Application No: FP/90/21/PD

Site Address: 23a Felpham Road Felpham PO22 7DA

Description of works: Notification of Prior Approval under Schedule 2, Part 3, Class M of the Town & Country (General Permitted Development (England) Order (as amended) for the change of use from shop (A1) to residential (C3).

Thank you for your internet representation made on 15th May 2021 which has been recorded as an objection with the comments as follows:

Drg. no. 2017/02 Sept. 2020
O'NEILL ARCHITECTURAL SERVICES
Tel: [01243] 531333

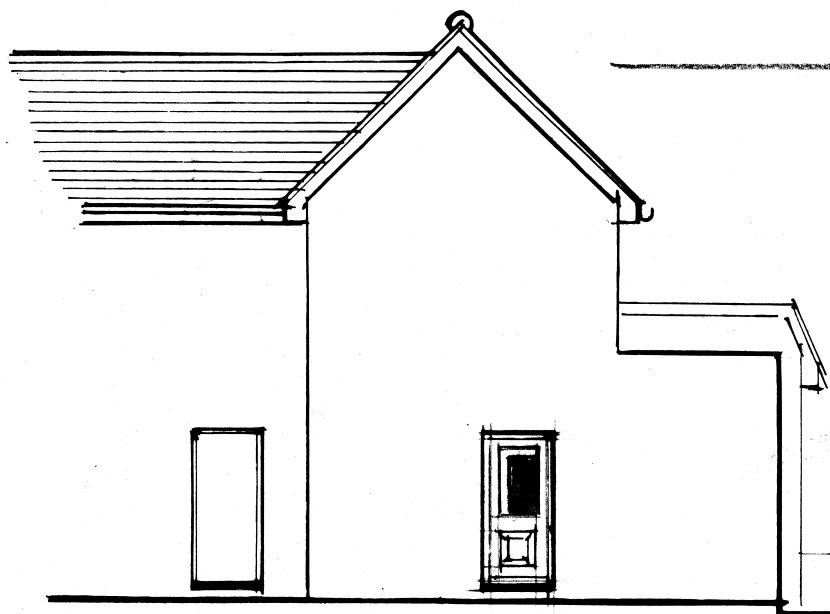
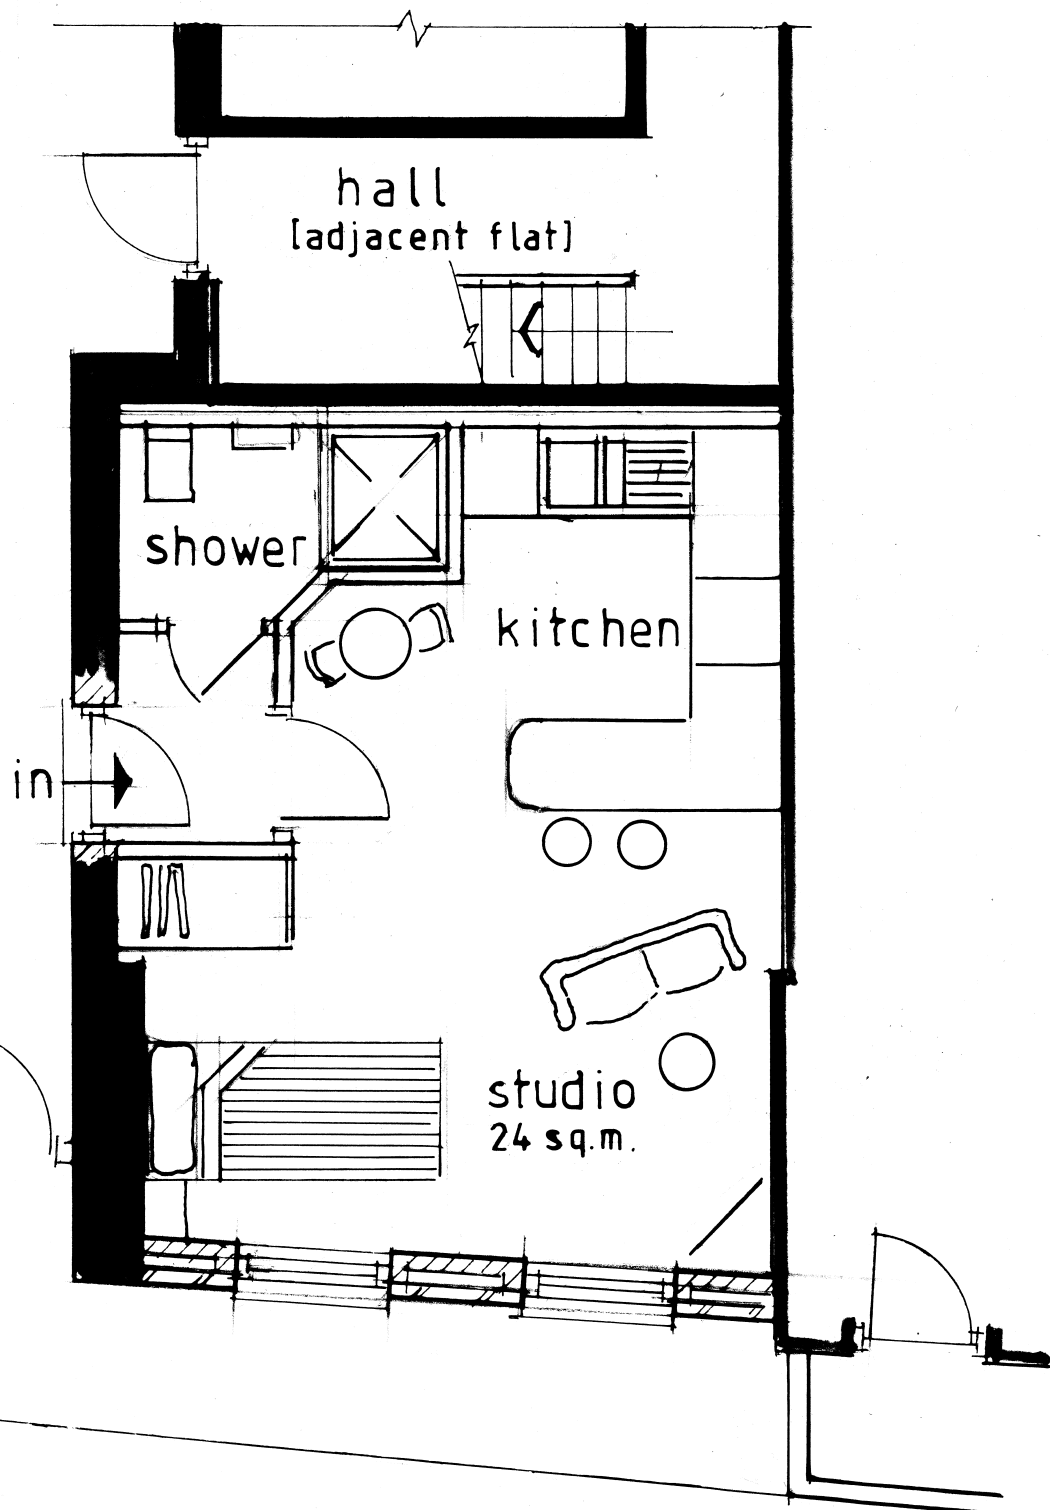
I bought the property in September 2014 and documentation from Land Registry show a Right of Way on foot over the alleyway for Flats 1 and 2 23A Felpham Road. There is NO Right of Way for 23A Felpham Road. An entrance in the alleyway is therefore not possible.

Even if there were a Right of Way there is no space or provision for refuse bins.

A revised street elevation with a door onto Felpham Road, to reflect what is already in place would be an alternative option.

Given the square meterage of the proposed studio, single person occupancy must be a condition.
